Outer Dowsing Offshore Wind

Response to Section 51 Advice

Schedule of Changes for Plans

Document Reference: 2.0

This document may only be used for the purpose for which it was commissioned and in accordance with the terms of engagement for that commission. Unauthorised use of this document in any form whatsoever is prohibited.

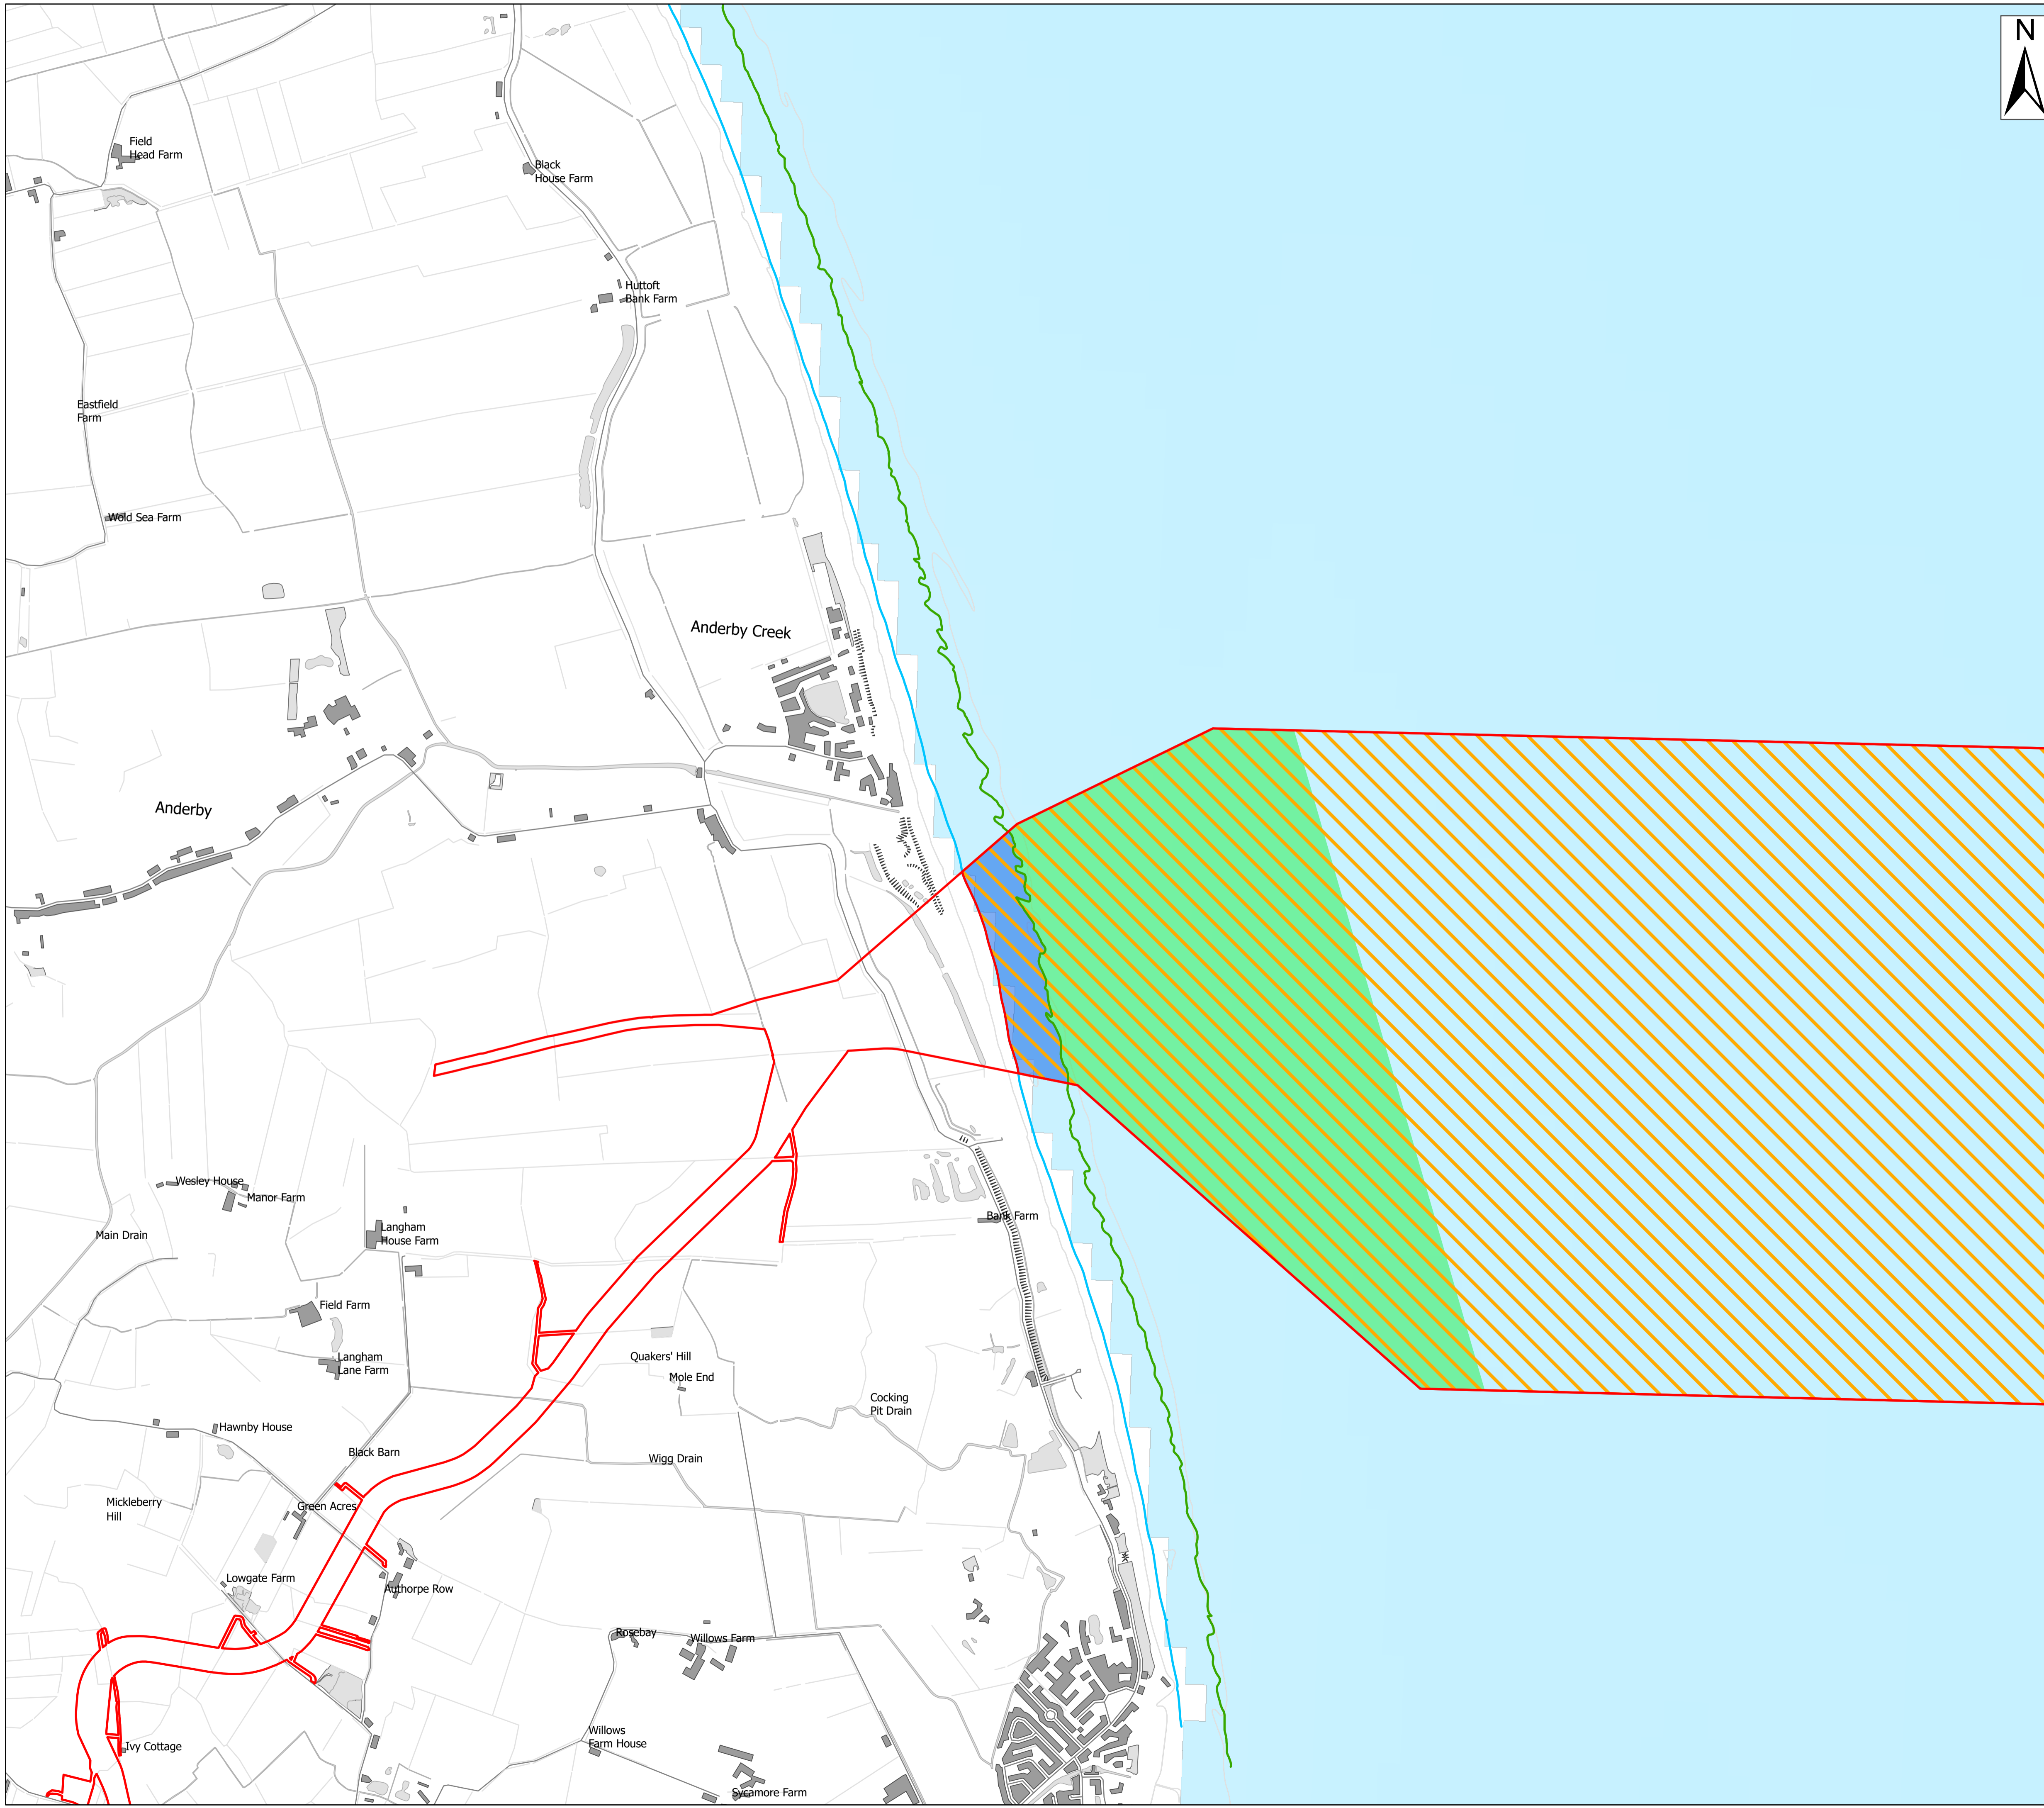
| Plan Numbers | Reference | Plot Number(s) if appropriate | Date of Change | Revision Change | Change Made | Reasons for Change |
|--------------|-----------|-------------------------------|----------------|-----------------|---|--|
| 2.2 | | N/A | July 2024 | V2 | Updated to reflect refined Order Limits | Updated Order Limits due to updated MHWS/MLWS datasets |
| 2.2 | | N/A | July 2024 | V2 | Amended works descriptions to better align with the DCO | Section 51 Advice request to align key text with the draft DCO works descriptions. |
